WEST SUSSEX COUNTY COUNCIL CONSULTATION

TO:	Arun District Council FAO: Mrs A Gardner
FROM:	Highways, WSCC
DATE:	31/05/2018
LOCATION:	14-18, Surrey Street, Littlehampton, West Sussex, BN17 5BG
SUBJECT:	LU/67/18/PL Change of use of part of public highway for external seating area at front comprising of 4 No. tables & 8 No. chairs. This application may affect the setting of a listed building. More information.
DATE OF SITE VISIT:	n/a
RECOMMENDATION:	Advice / Modification
S106 CONTRIBUTION TOTAL:	n/a

PROPOSED PAVEMENT CAFE

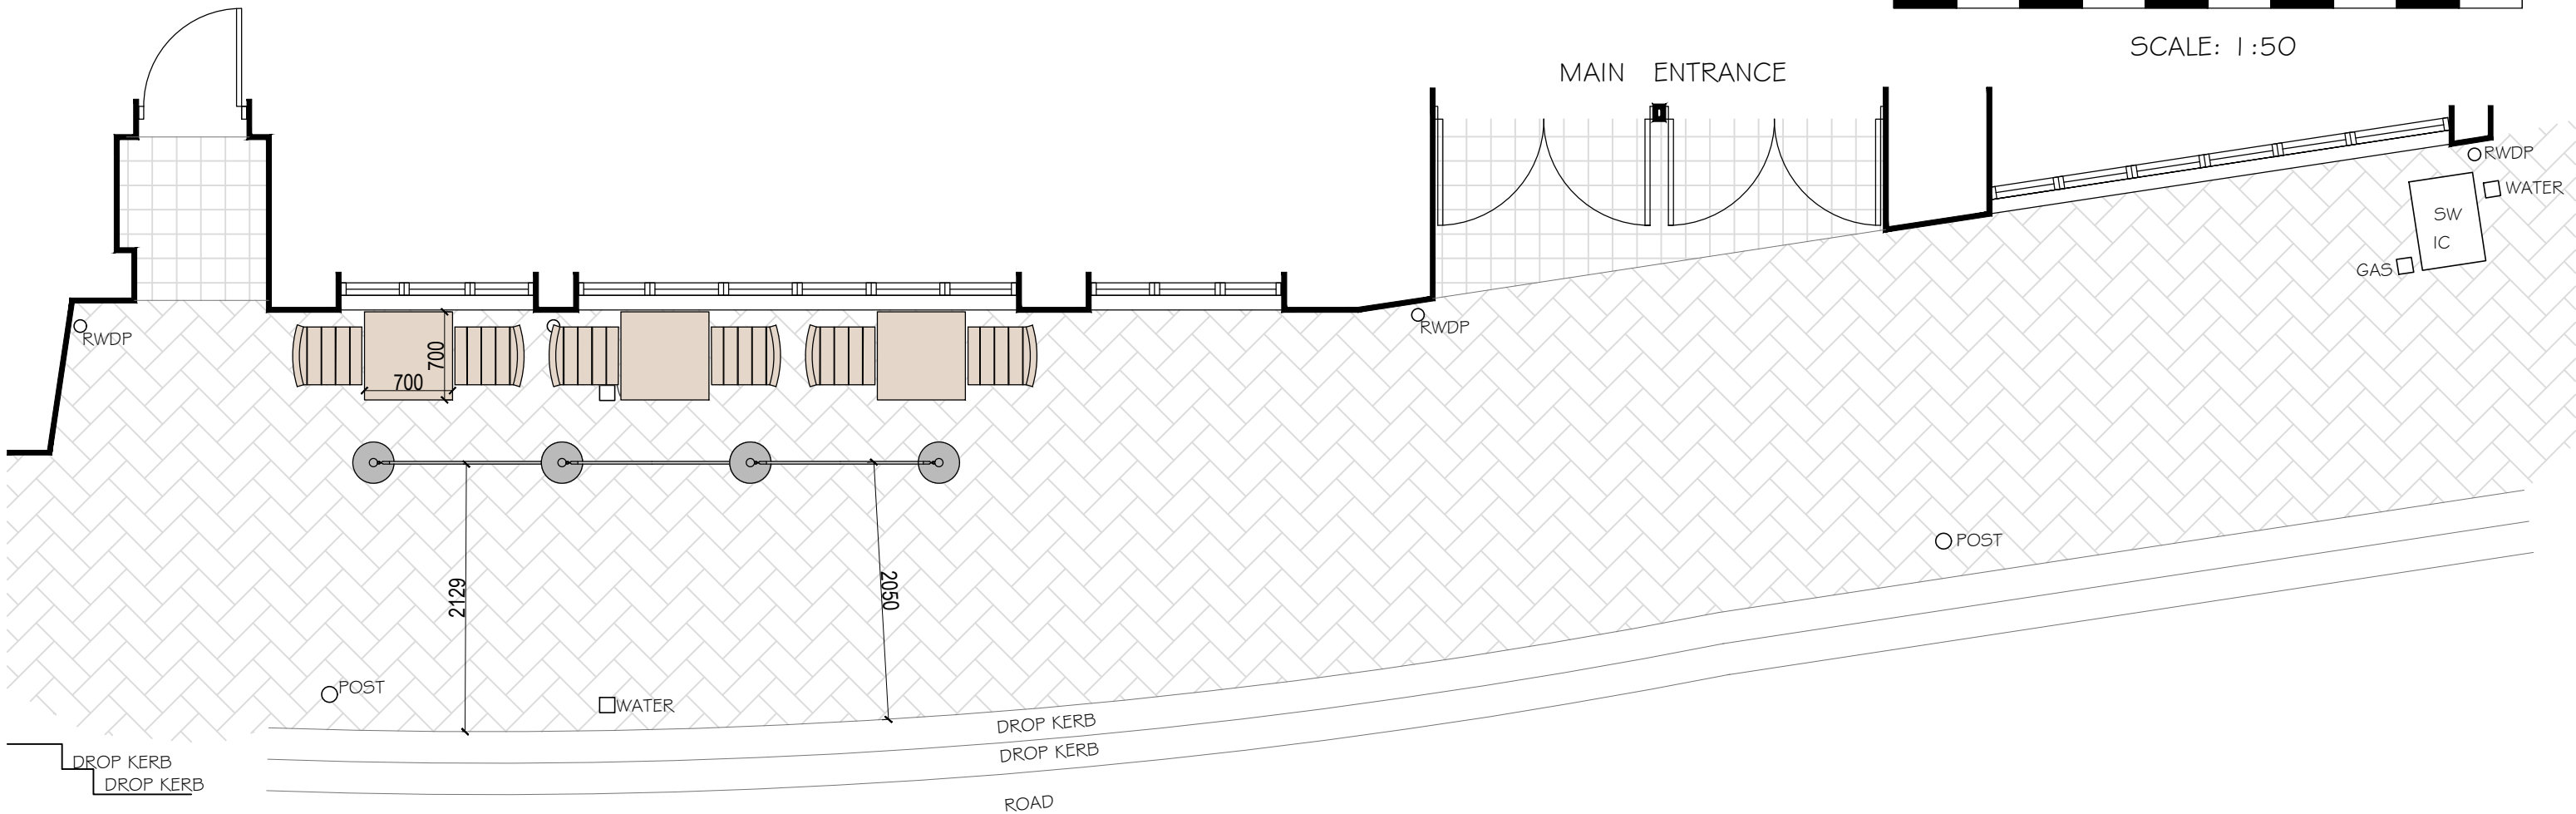
After inspection of the revised plans the proposed would still result in a narrowing of the footway to circa 1.8 metres once the stands for the rope and pole barriers have been taken into consideration.

A post is annotated at the southern extent of the frontage, using desktop evidence this post was removed some when between 2014 and 2015. The applicant should check this detail and remove this annotation if the post is no longer in place.

The Local Highways Authority would reiterate that Manual for Streets advises a minimum footway width of 2.0 metres. This is expanded upon in section 3.1 of the DFT publication 'Inclusive Mobility' which states the following regarding footway widths:

"A clear width of 2000mm allows two wheelchairs to pass one another comfortably. This should be regarded as the minimum under normal circumstances."

The footway width in this location currently accords to recognised guidance. The Local Highways Authority would therefore not wish to seek any reduction below recognised guidance and standards.

I note the frontage of the public house does provide the opportunity to provide a reduced level of tables and chairs while retaining minimum acceptable footway widths across the frontage as advised above. The Local Highways Authority would advise that the rope and pole barriers are removed or pushed back to provide maximum footway with and/or further reducing the quantity of tables and chairs provided.
